STATE OF WASHINGTON
DEPARTMENT OF ECOLOGY

March 16, 2016

Re: SP-15-00009

Thank you for the opportunity to comment on the short subdivision of approximately 80.5 acres into 4 lots, proposed by Jeff and Cindy Strole. We have reviewed the application and have the following comments.

**STROLE AG SHORT PLAT SS - XX-XX
PREPARED FOR
JEFF STROLE**
A PORTION OF THE W 1/2 OF SECTION 35
TOWNSHIP 19 N., RANGE 18 E., W.M.

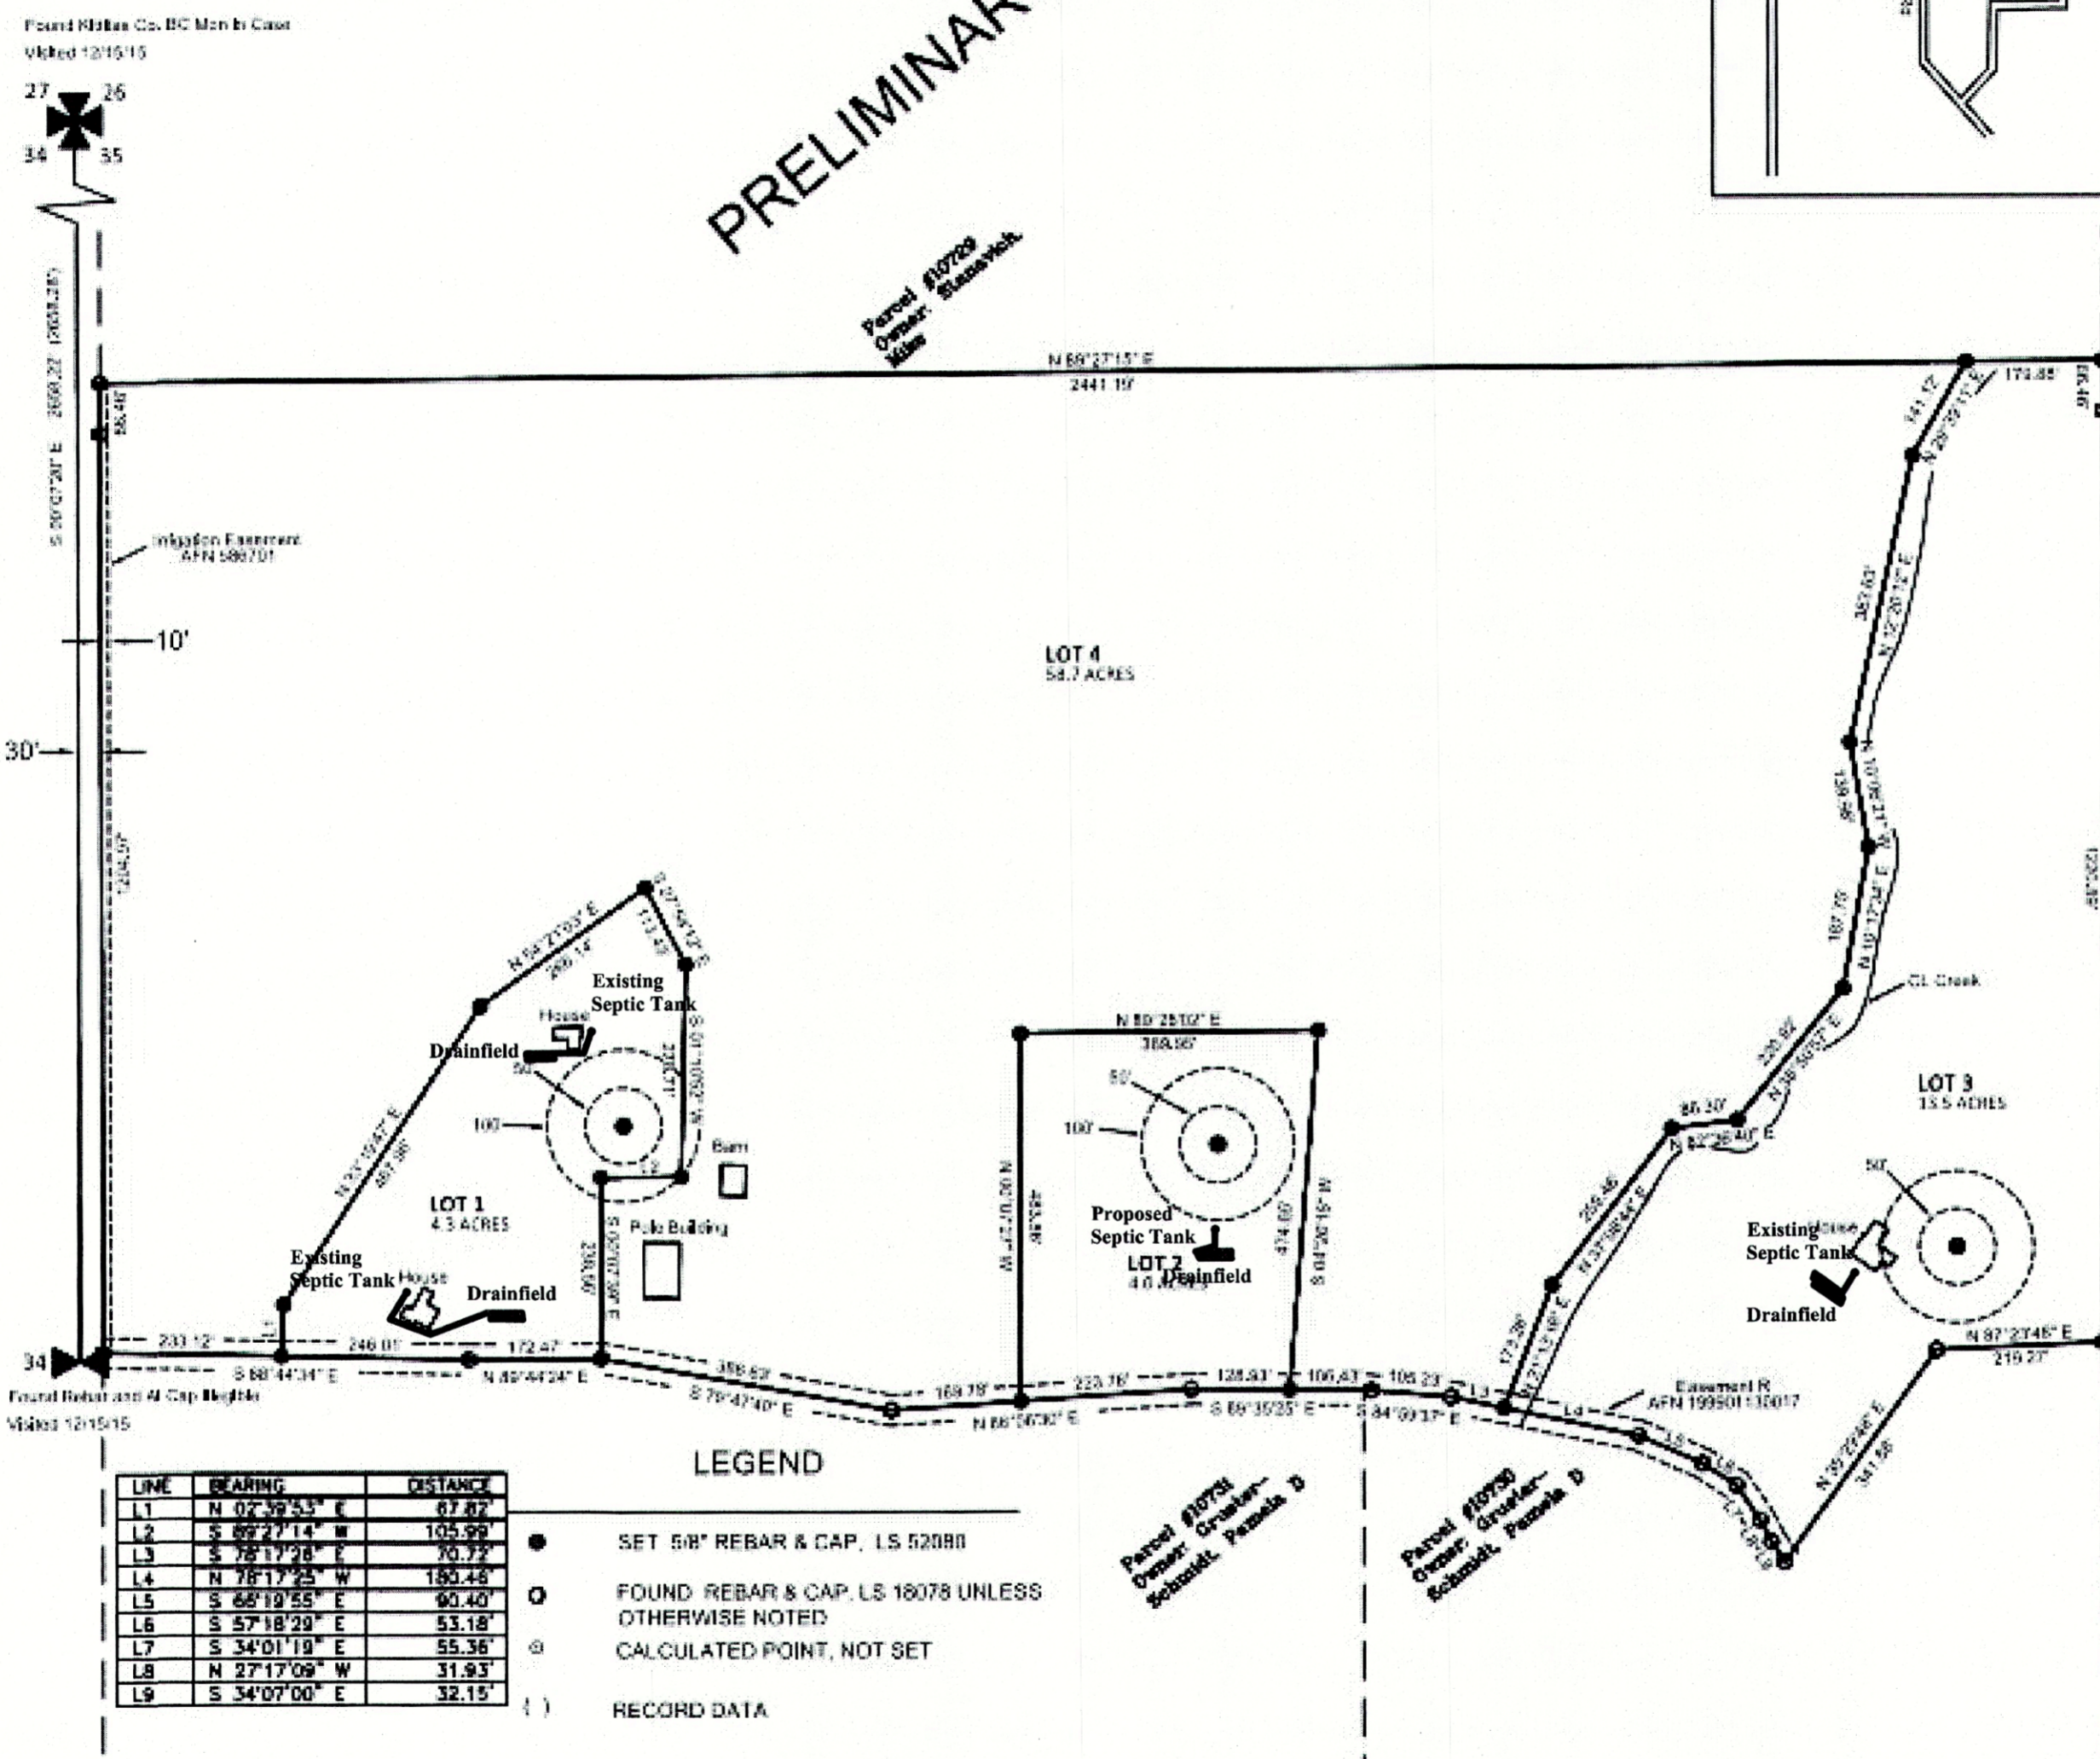
A wetland delineation should be done for proper placement of building envelopes and roads. Lots should be designed which do not require intrusion into wetland areas or their required buffers zones for access or infrastructure (wells and utilities, etc.) and buildings. The National Wetland inventory maps may not show the full extent of wetlands or their exact location and therefore on-site investigation to identify wetland areas should be required before final lot line locations and building permits are approved.
